Our reference: P-801089-B9N3  
Contact: Tania Shephard  
Telephone: (02) 4732 7797

26 November 2024

**Council Response to DA 2 Modification Report - DA86/2720-Mod-12 - Penrith Lakes at 89-151 Old Castlereagh Road, Castlereagh, NSW, 2749**

Figure 2: View loss comparison between 1:6 and 1:20 batter slopes as viewed from Castlereagh Road

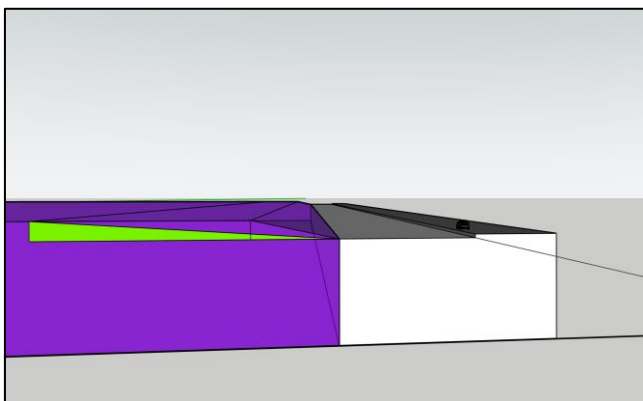
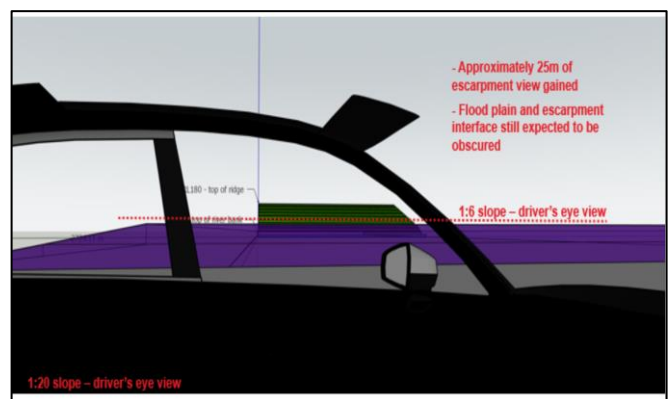
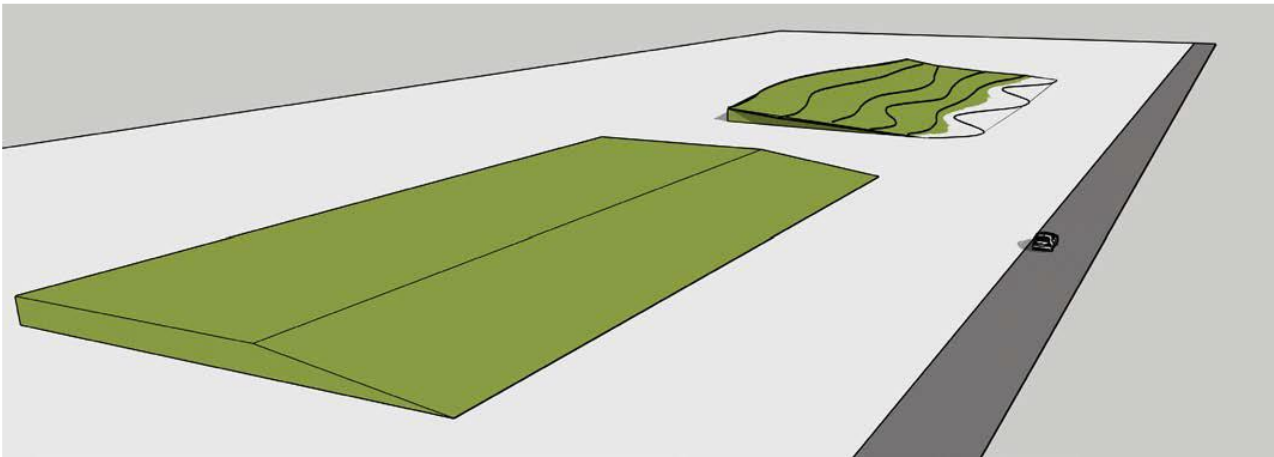
- d) Batters are proposed along Castlereagh Road and consideration should be provided as the visual impact of such, the method of retaining fill and potential for landscaping of the batter, noting the gradient proposed.

The additional fill material will have additional visual impact from Castlereagh Road and for key scenic vistas noting the levels of fill proposed.

Appendix A | Contour Heat Map

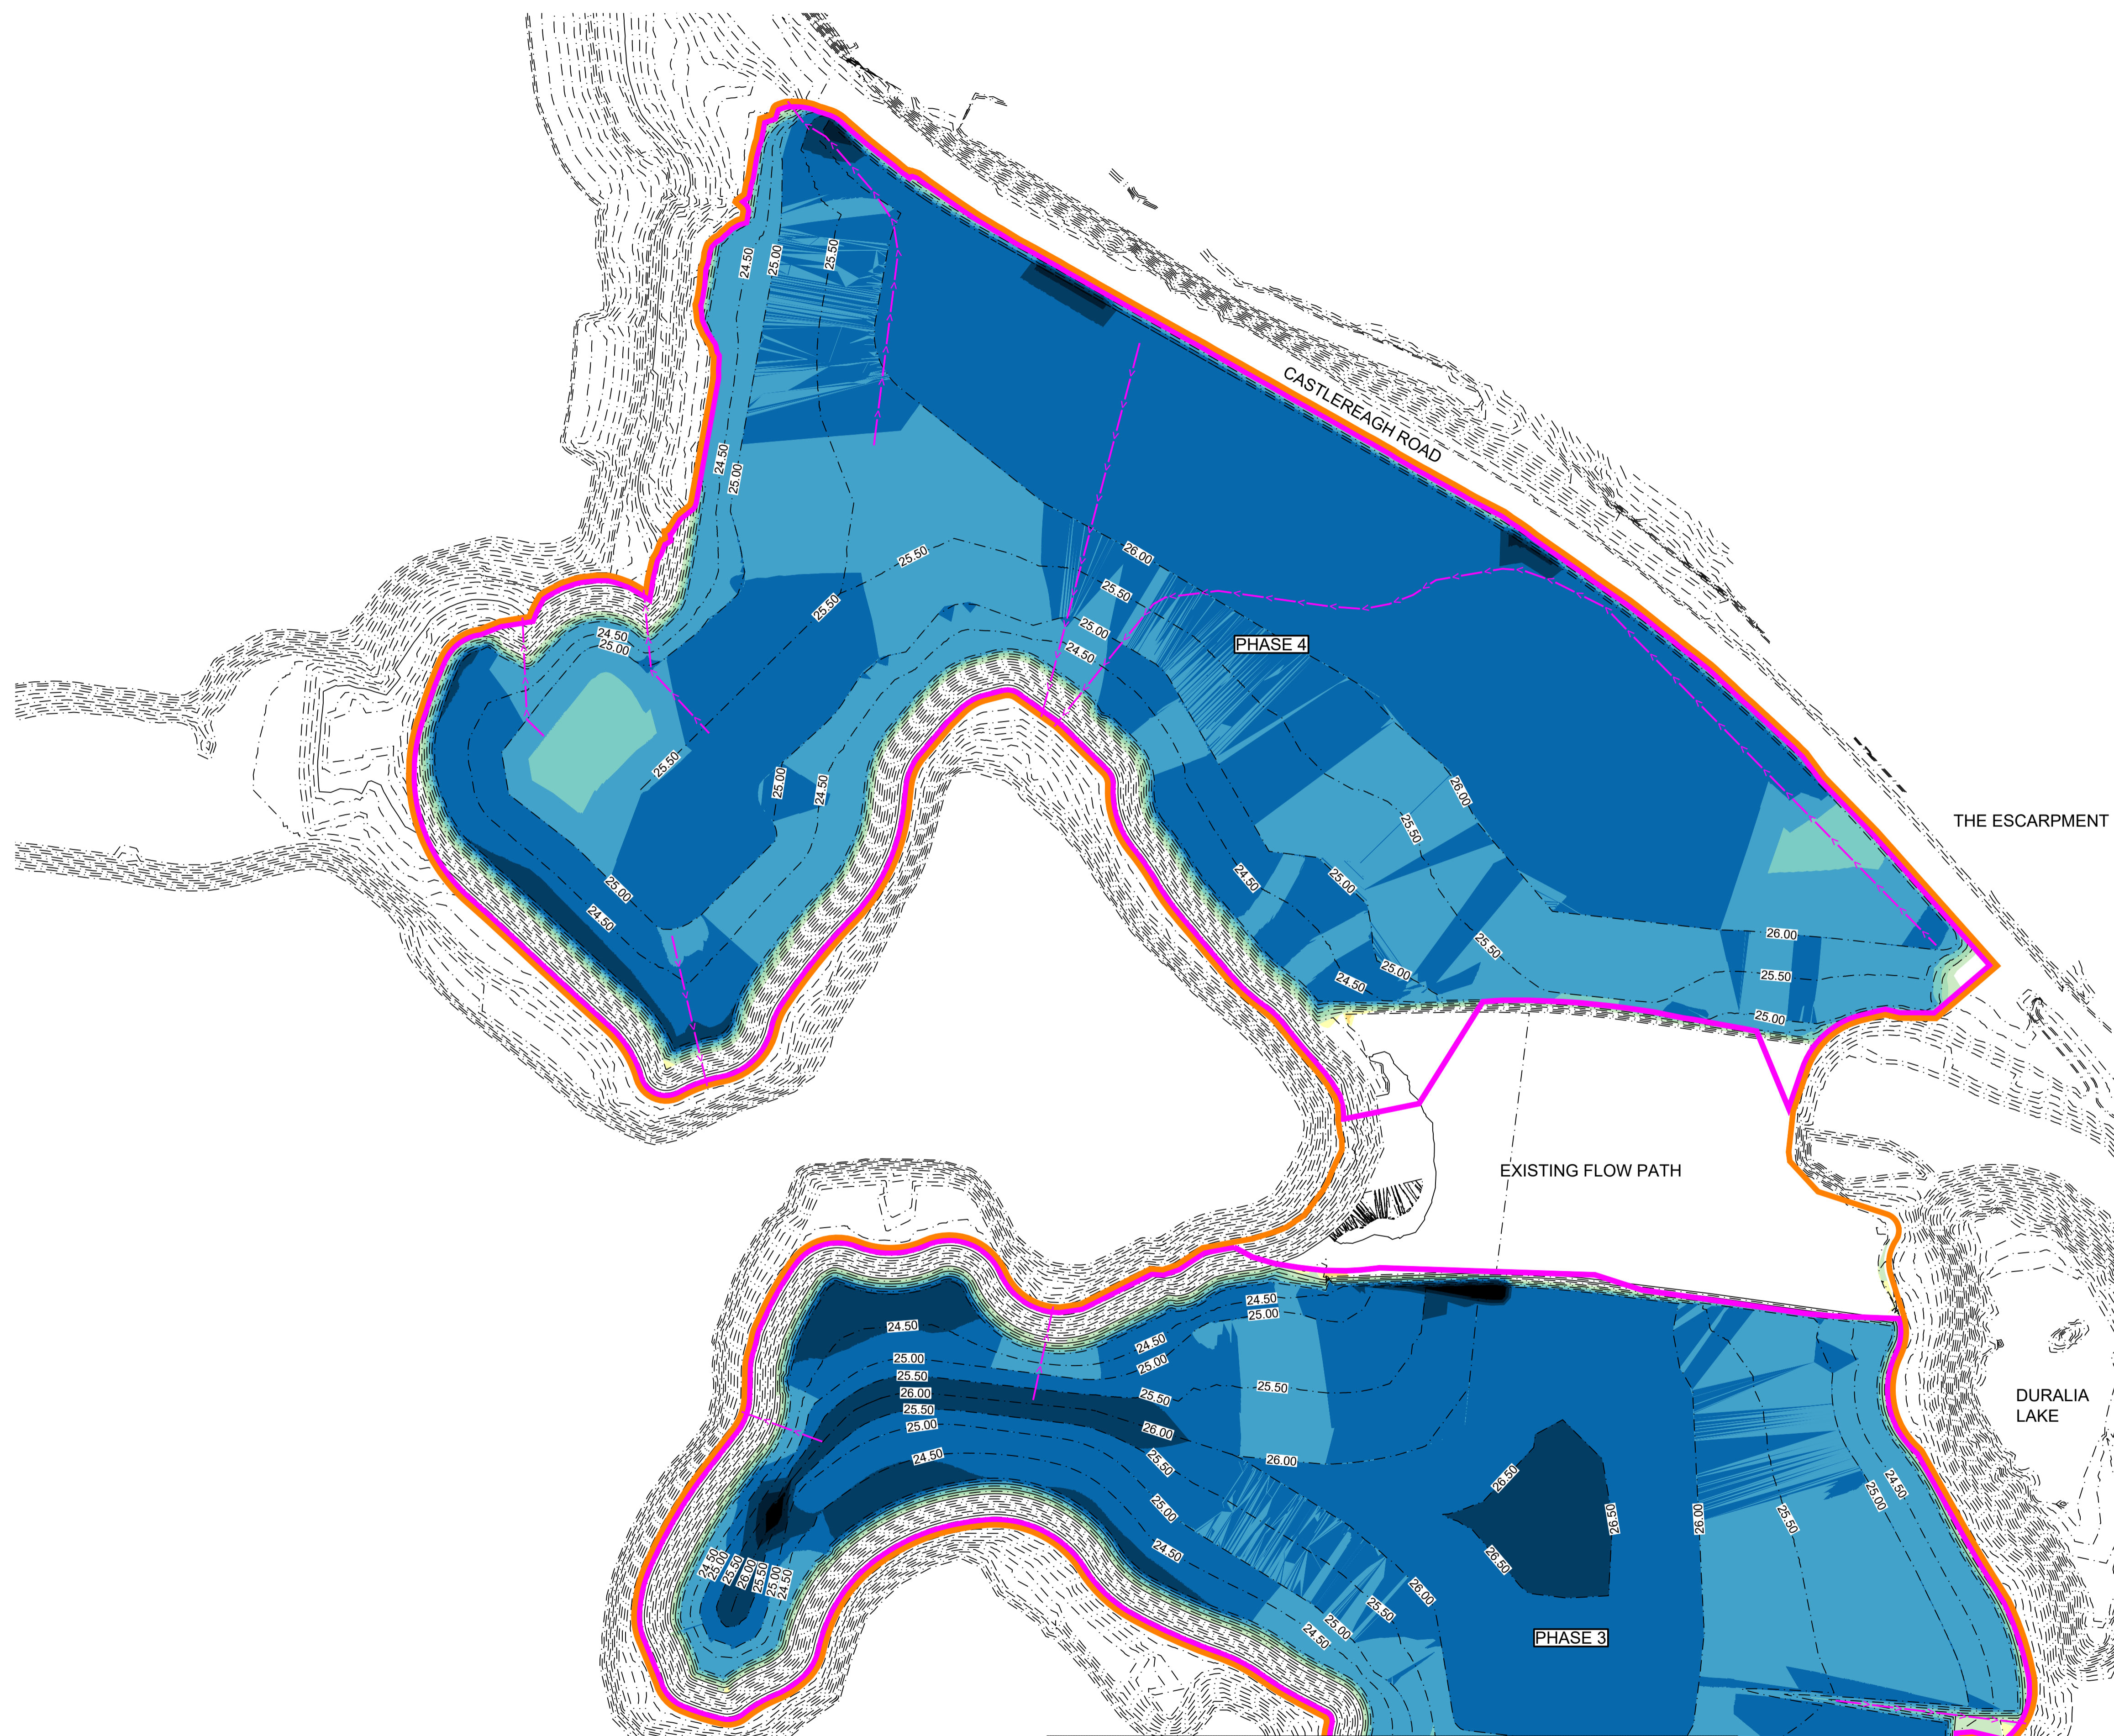
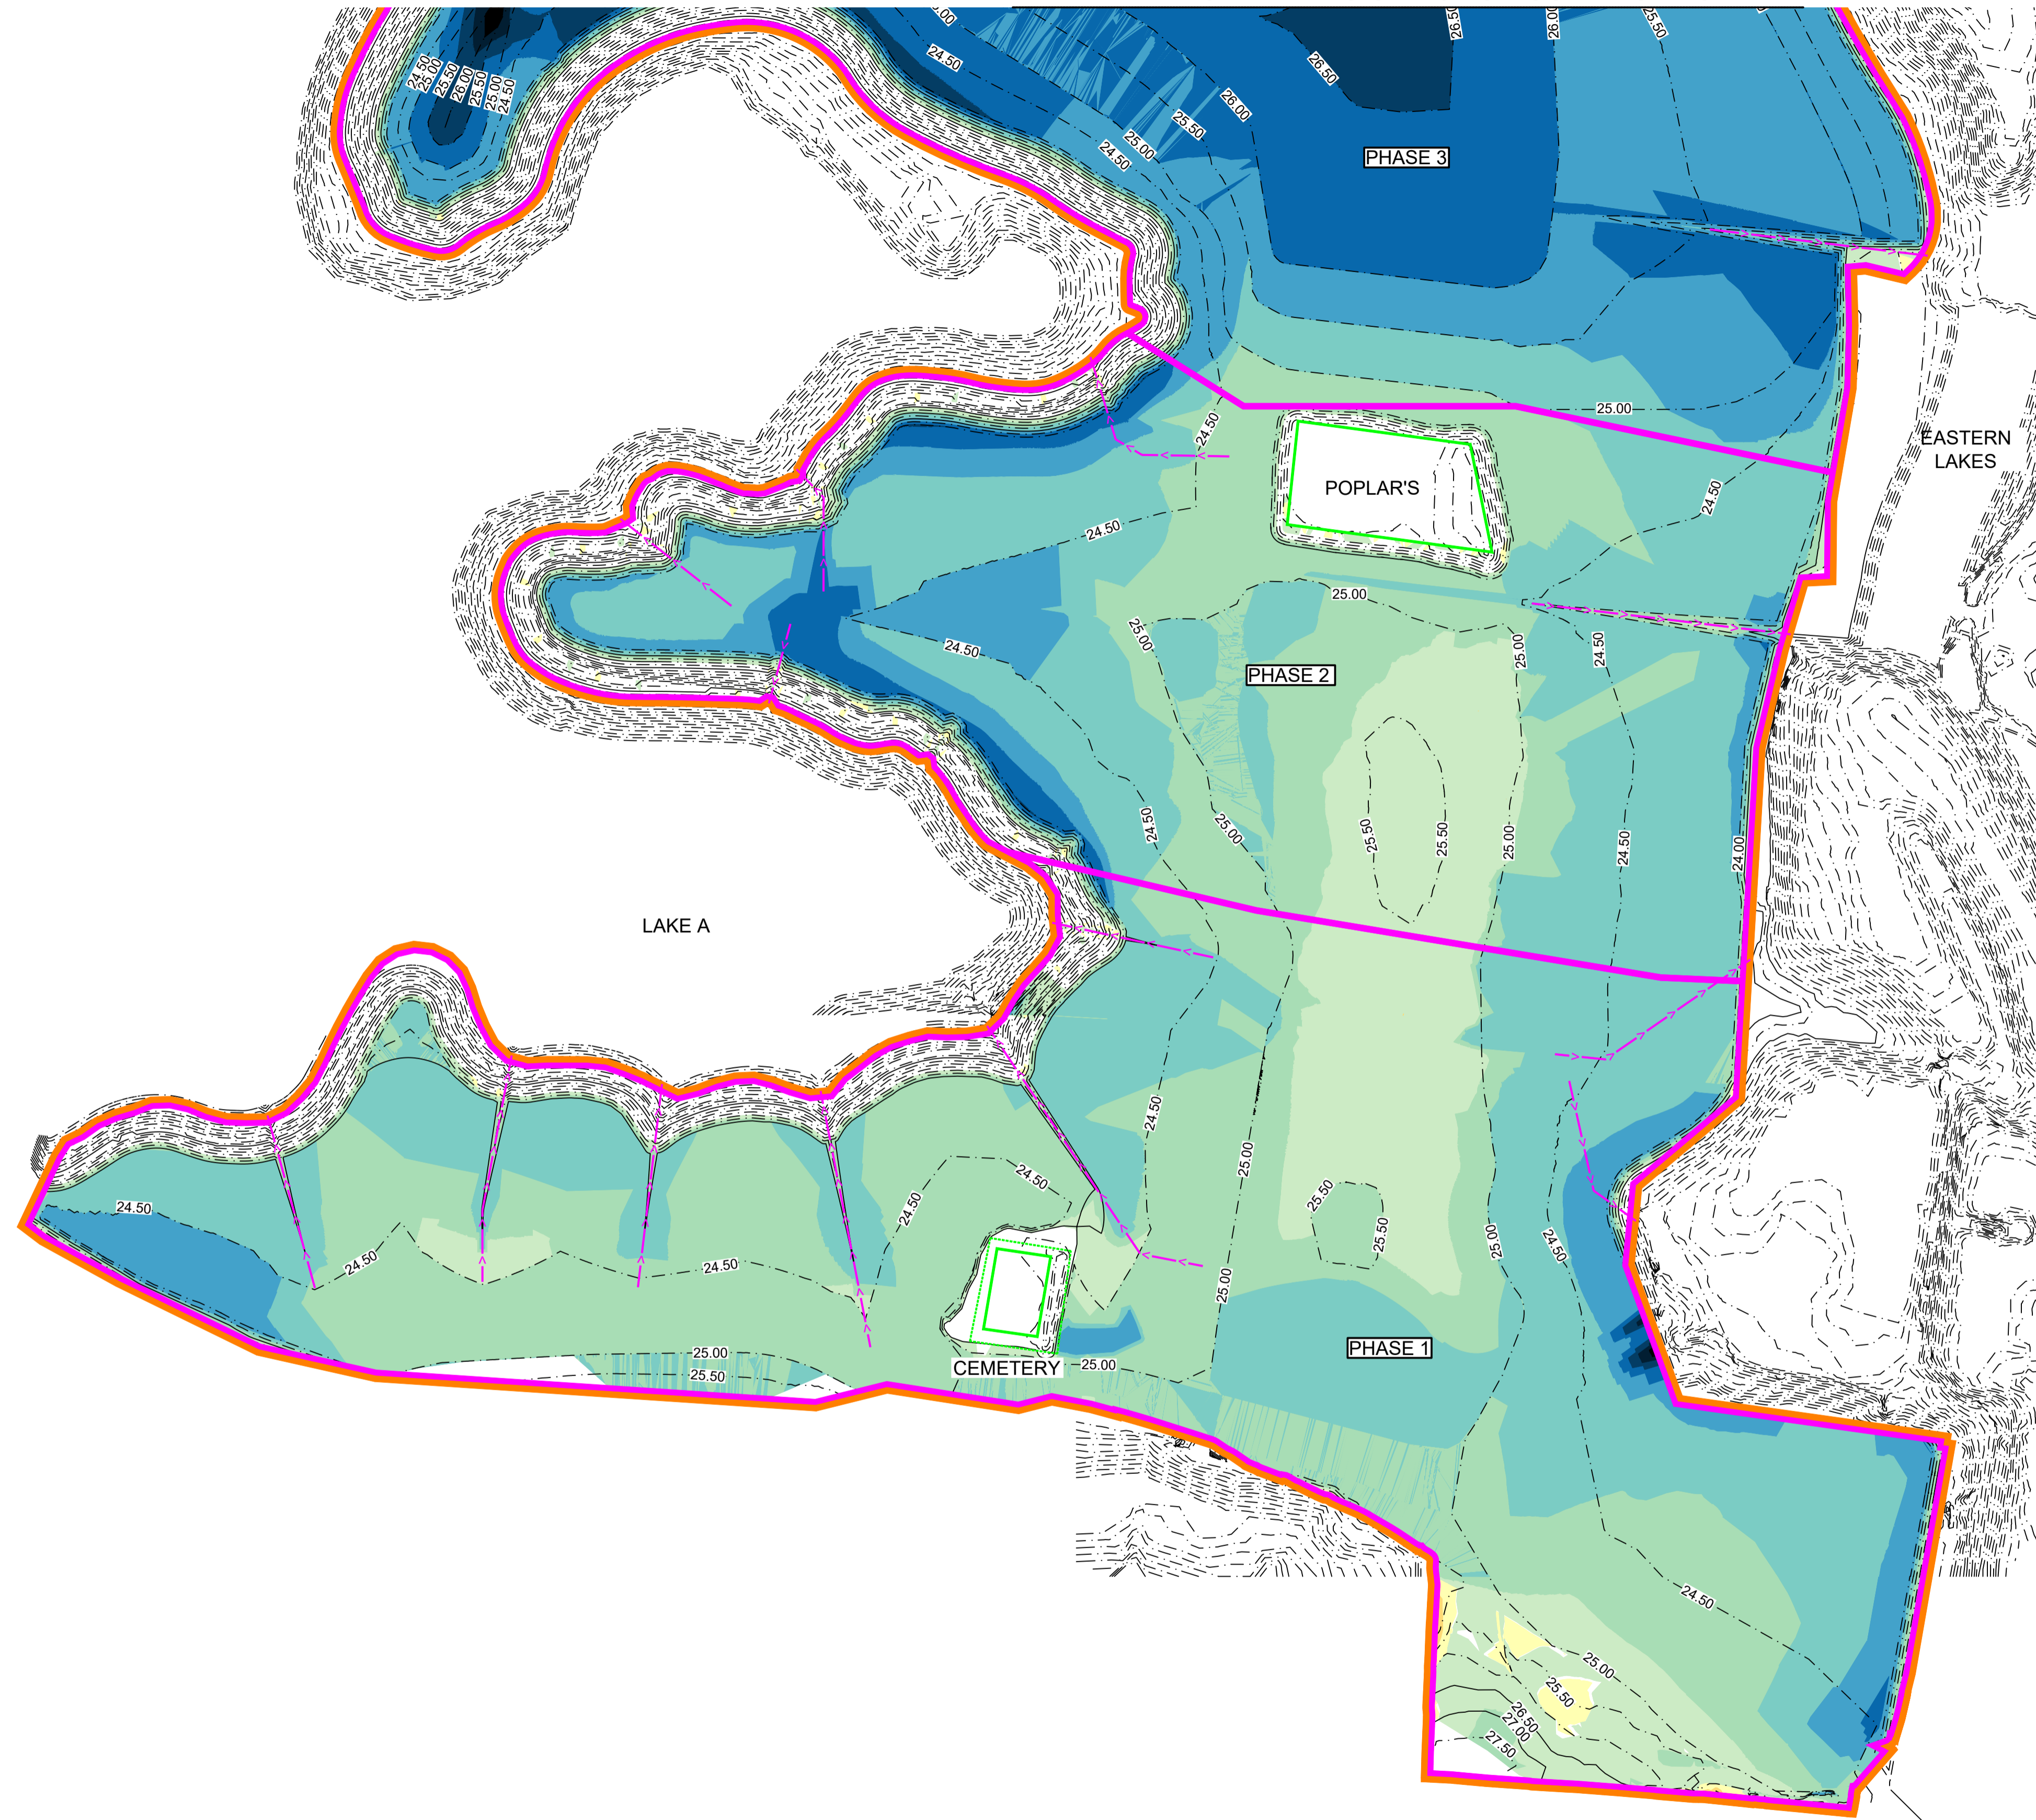
- a) It is noted that the application seeks to fill beyond the 1:500 year flood level and it is understood that a one metre freeboard has been considered. However, the proposed finished fill level exceeds the freeboard requirement in the majority. The reason for this is unclear and should be justified.

- b) Justification for excessive fill, over and above the freeboard requirement, should be considered with regard to the impact to flood storage and regional flooding.
